The Secretary  
NSW Planning, Industry & Environment

13 October 2021

I refer to the Department's below email of 13 September 2021 regarding the public exhibition of the Environmental Impact Statement (EIS) for State Significant Development SSD-18204994 Snack Brands Manufacturing Facility for 'Construction and operation of a chips/snack foods manufacturing facility to connect to the existing adjoining Snack Brands Warehouse and Distribution facility' at 2 and 14 Distribution Drive, Orchard Hills (Lots 10 and 11 DP 271141) in the Penrith City Local Government Area. Submissions need to be made to the Department by 13 October 2021.

Drawing Title:
Landscape Plan
DWG No:

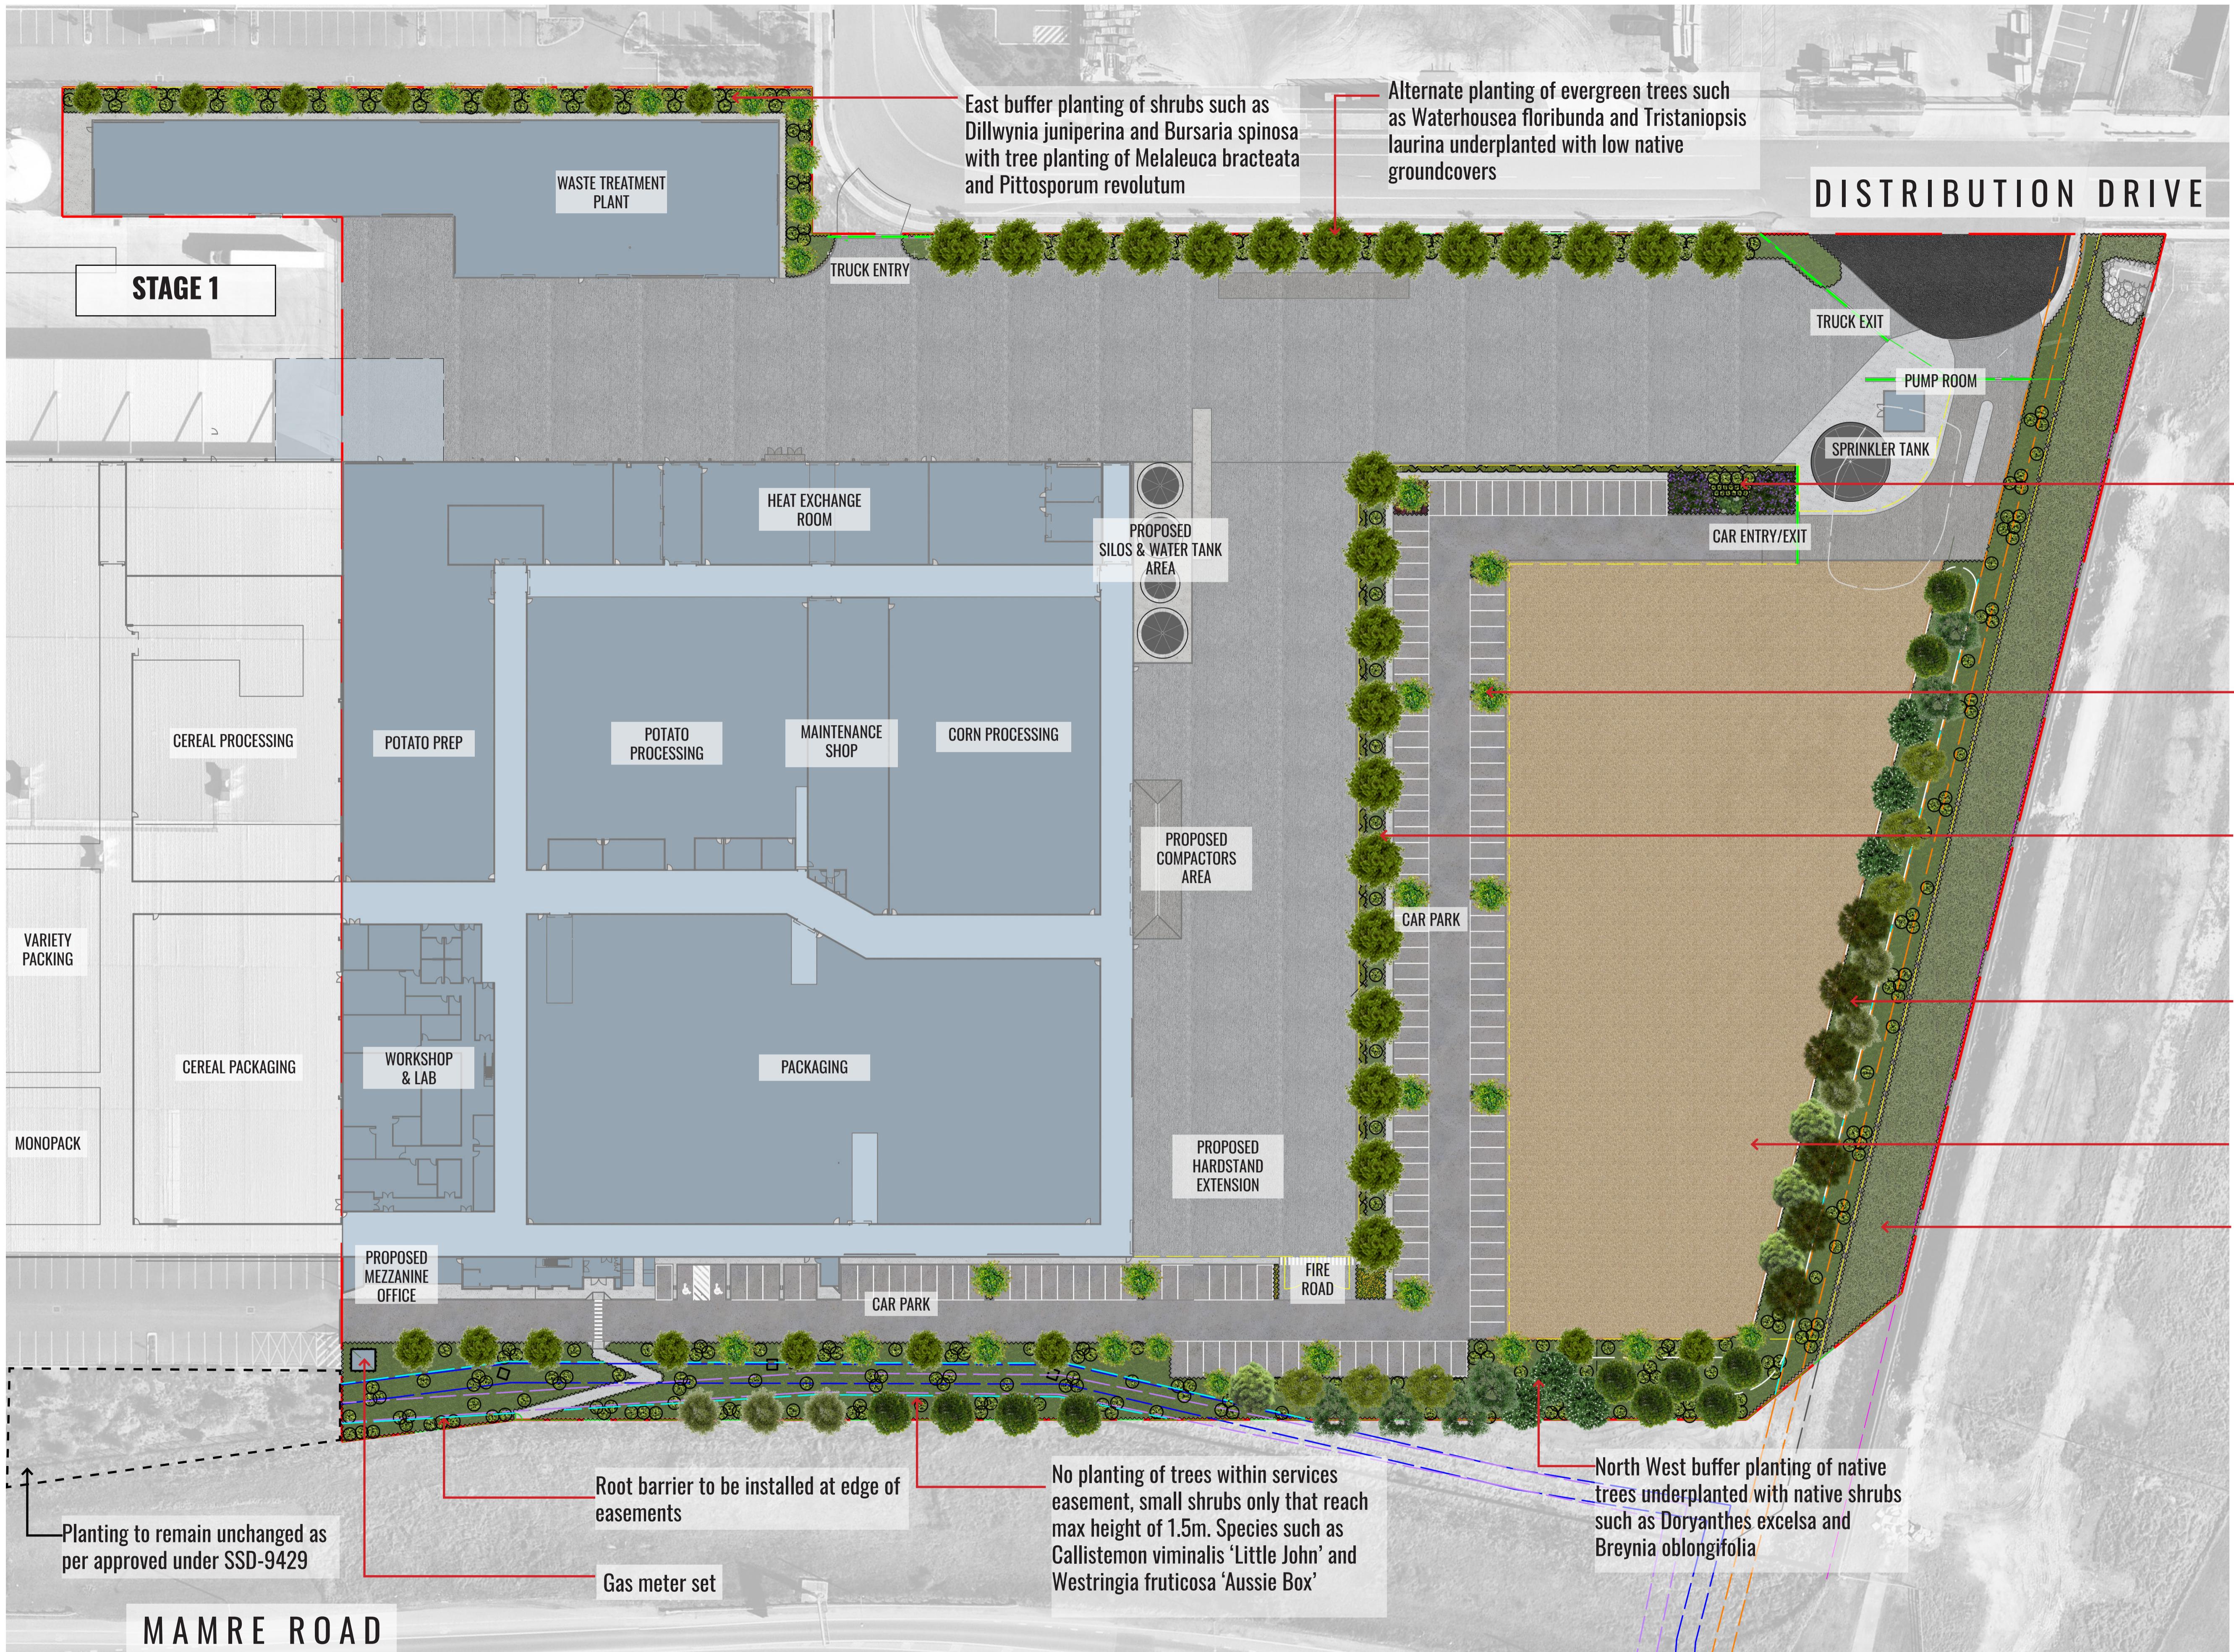
Suitable planting needs to be undertaken in proximity of electricity infrastructure (including any new electricity infrastructure required to facilitate the proposed development). Only low growing shrubs not exceeding 3.0 metres in height, ground covers and smaller shrubs, with non-invasive root systems are the best plants to use. Larger trees should be planted well away from electricity infrastructure (at least the same distance from overhead power lines as their potential full-grown height) and even with underground cables, be installed with a root barrier around the root ball of the plant.

Screening vegetation around a padmount substation should be planted a minimum distance of 800mm plus half of the mature canopy width from the substation easement and have shallow / non-invasive roots. This is to avoid trees growing over the easement as falling branches may damage the cubicle and the electricity infrastructure as do tree roots. All vegetation is to be maintained in such a manner that it will allow unrestricted access by electrical workers to the substation easement all times.
